RE: 211 Pacific Highway St Leonards - SSD – Response to Submissions

HERITAGE IMPACT STATEMENT

211 Pacific Highway St Leonards

TITLE  
PAVEMENT DETAILS SHEET 1

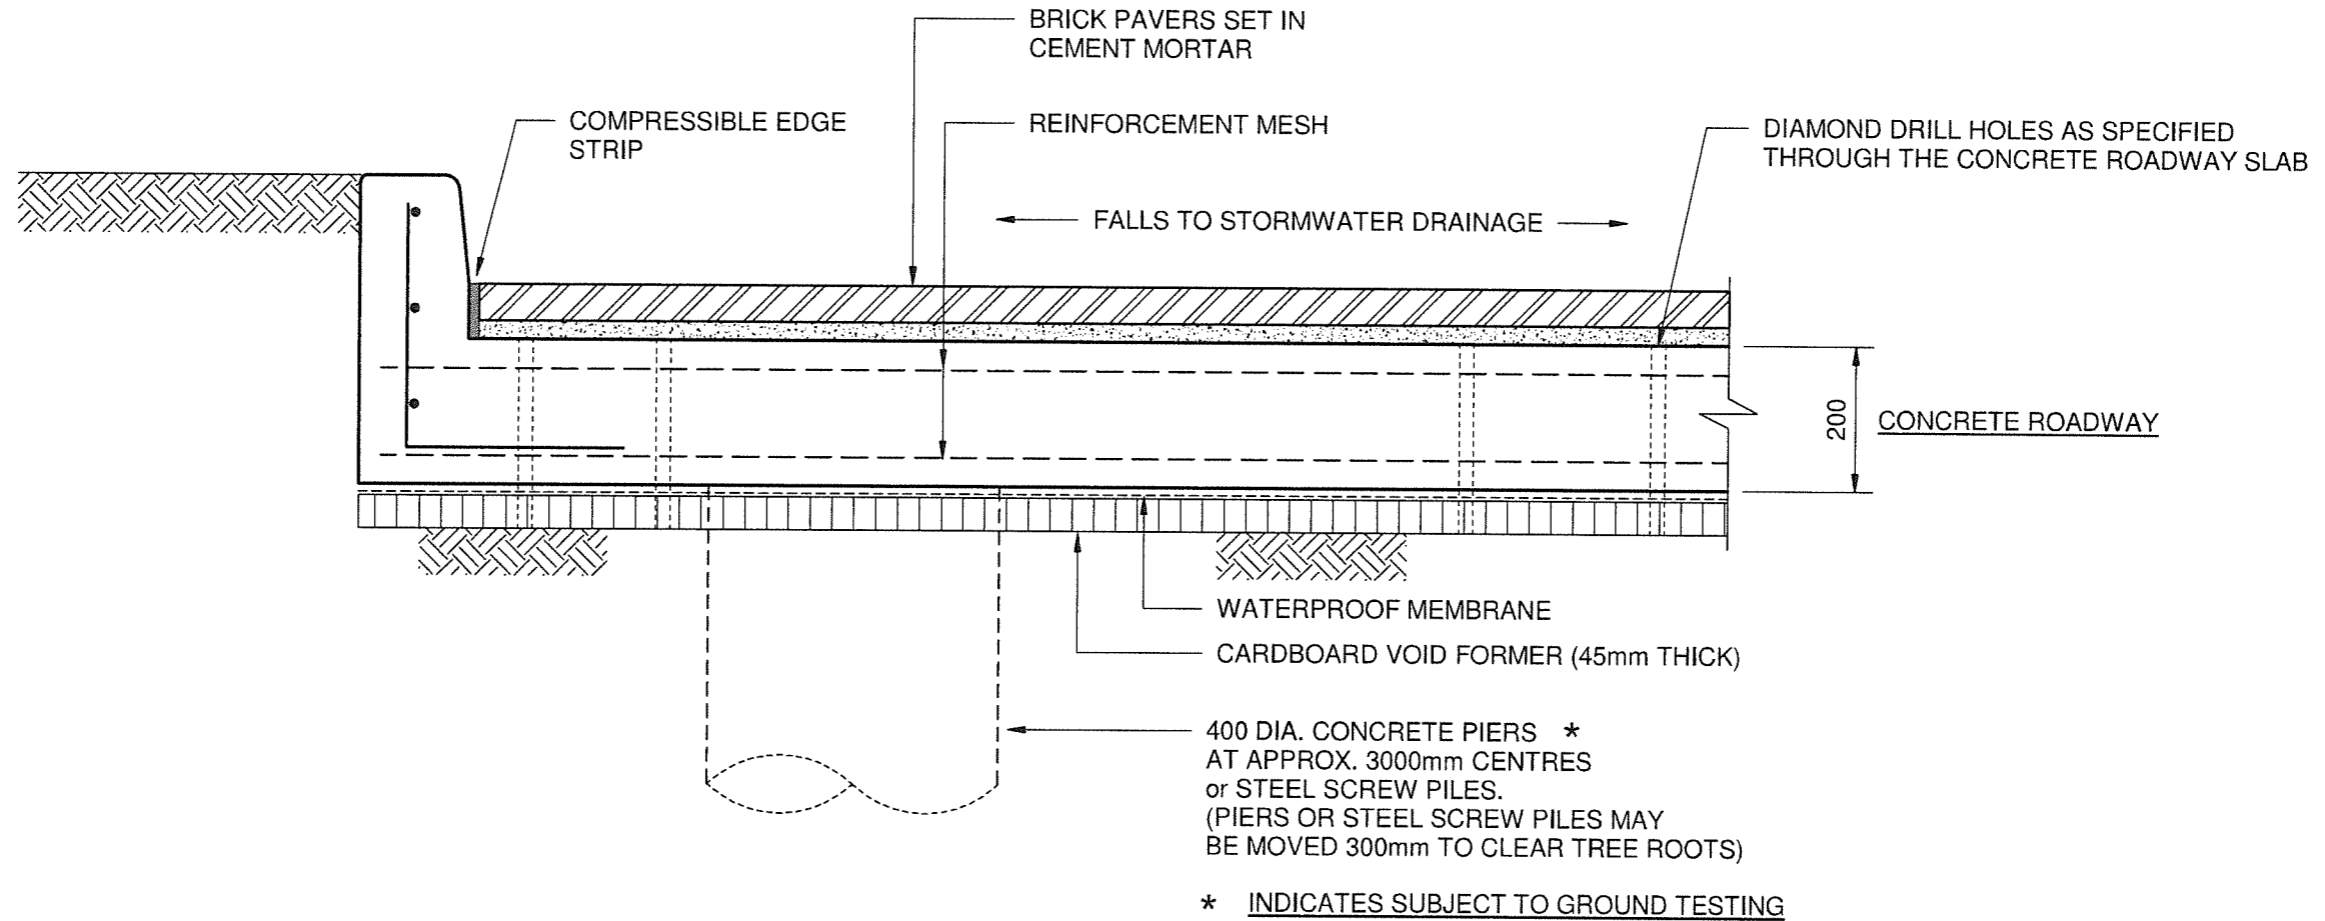
AGENCY	RESPONSE TO SUBMISSION
<p>The Department considers that the extent of proposed paving for the five 'Kiss and Drop' spaces shown on drawing No. SSD01 and its proposed charcoal colour would significantly alter the appearance and visual consistency of The Avenue resulting in significant impacts on the physical and visual character of the state heritage item. The Department is concerned that the Heritage Impact Statement (HIS) prepared by 'NBRS Architecture' has not accurately ascertained the extent of new paving proposed and has not therefore provided a proper assessment of heritage impact. The Avenue currently contains a combination of paving, soft gravel and grass in uniform proportions along the majority of its length towards to north. Drawing No. SSD01 incorrectly notates the area of soft gravel and grass adjoining the pedestrian pathway as 'line of existing paving'. The HIS states that proposed works include "re-laying of existing paving". This description is inaccurate as the soft gravel and grass is proposed to be replaced with charcoal coloured paving bricks, resulting in a fully paved area between the school site and Council car park which significantly departs from the character of the ground surface treatment along the remaining length of The Avenue. Further, although indicated on drawing No. SSD01, the EIS has not discussed the proposed paving works to The Avenue in full detail.</p>	<p>The existing pavers and paving layout dates from the 1970s and is not considered a significant design element of The Avenue.</p> <p>The colour of the new paving has been reconsidered and is now shown in the revised Site Plan. It provides a similar colour material to the existing 1970s paving. The retention of existing paving retains the visual uniformity of paving along the length of The Avenue.</p> <p>The outline of the existing paving is defined by a brick header course where it abuts the new paved area. The new paved area is in an area of gravel with limited seasonal grass growth due to heavy shading and no reticulation. It extends the area of full-width paving at the southern end of The Avenue.</p> <p>The revised Site Plan clarifies the extent of existing and new paving. The landscaped border with existing mature trees is retained between The Avenue and the Council carpark retaining principle design element of The Avenue as a tree-lined boulevard.</p>

<p>iv) The impact of increased traffic on the existing paving in The Avenue, and the future implication regarding repairing and reinforcing this road. It should be noted that the existing traffic on The Avenue is of an extremely limited nature originally designed to provide access for mourners to gravesites and related services.</p>	<p>The physical works required to create the new driveway do not involve the removal of any existing trees or impact upon the existing 1970s red brick paving of The Avenue.</p> <p>The existing paving which has been damaged by uncontrolled vehicle movements, tree roots and subsidence will be lifted and re-laid to provide a smooth and regular paved surface to continue pedestrian movement through the Cemetery. The remainder of the paving with the Cemetery will be protected from regular vehicle movements through the installation of removable bollards in accordance with the Gore Hill Plan of Management.</p> <p>The new paving system of the kiss and drop area has been engineered so as not to interfere with the root zone of established trees and allow room for trees to continue to grow over The Avenue with permeable paving and engineered substrate such that the existing trees between The Avenue and the council carpark are not detrimentally impacted by the proposed works.</p> <p>A paving header-course will be used to define the outline of the existing paving. The infill of permeable paver is carefully designed to allow trafficable paving over the root zone of the surrounding trees.</p>
